RE: SUB19-002/SEP19-005 – Proposed Preliminary Plat  
2825 W. Mercer Way, APN 2174502425  
Request for Additional Information, Third Review  
Blueline Job No. 13-118

This letter is in response to your review of the SUB19-002/SEP19-005 project. The plans have been revised per the comments in your letter dated 1/09/23. Below is a list of each comment with our responses in bold.

2/16/23
JOB NUMBER: 13-118
SHEET NAME: RS-01
SHT 6 OF 9

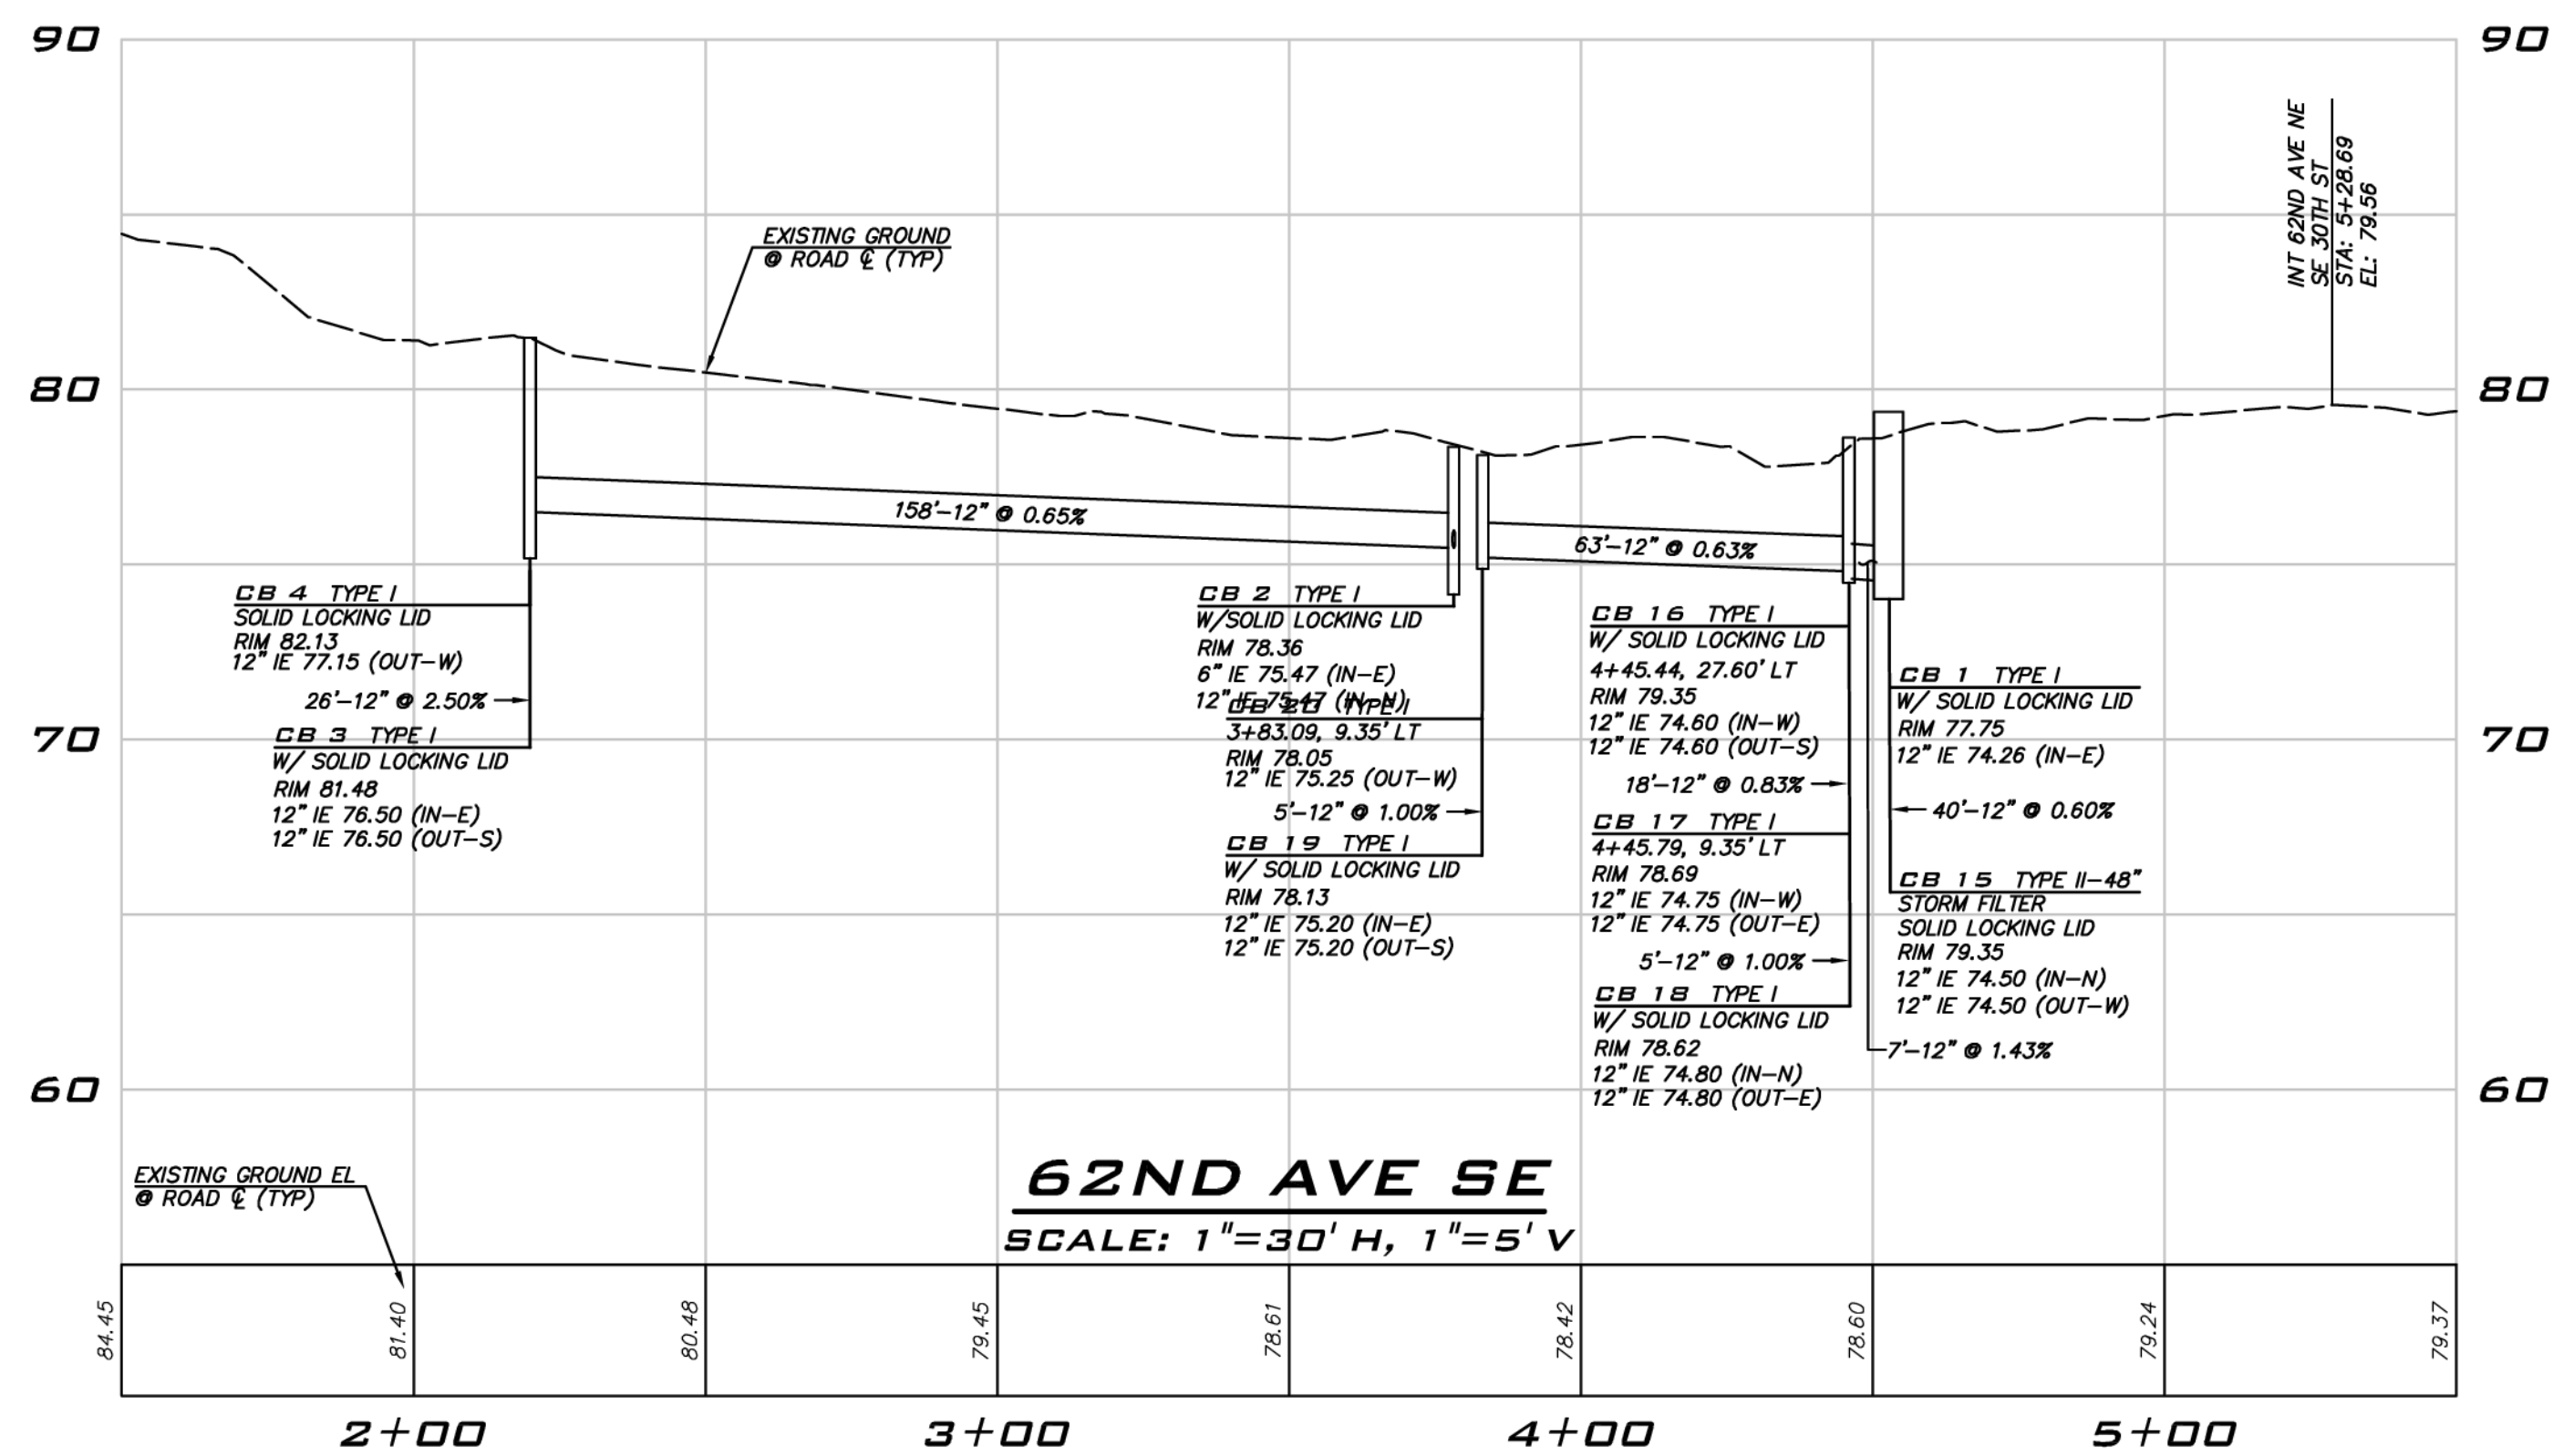
7. Fire Turn Around- Meets Standards  
IFC 503.2.4 The required turning radius of a fire apparatus access road shall be determined by the fire code official. (See Appendix B)  
Applicant must identify turn around area on plat map and provide a plan on how this area will be maintained for fire access only and not parked vehicles. Examples would be painted lines (maintenance agreement) and/or signage.

**Noted. A callout for the fire turnaround has been added to sheets SP-01 and RS-01.**
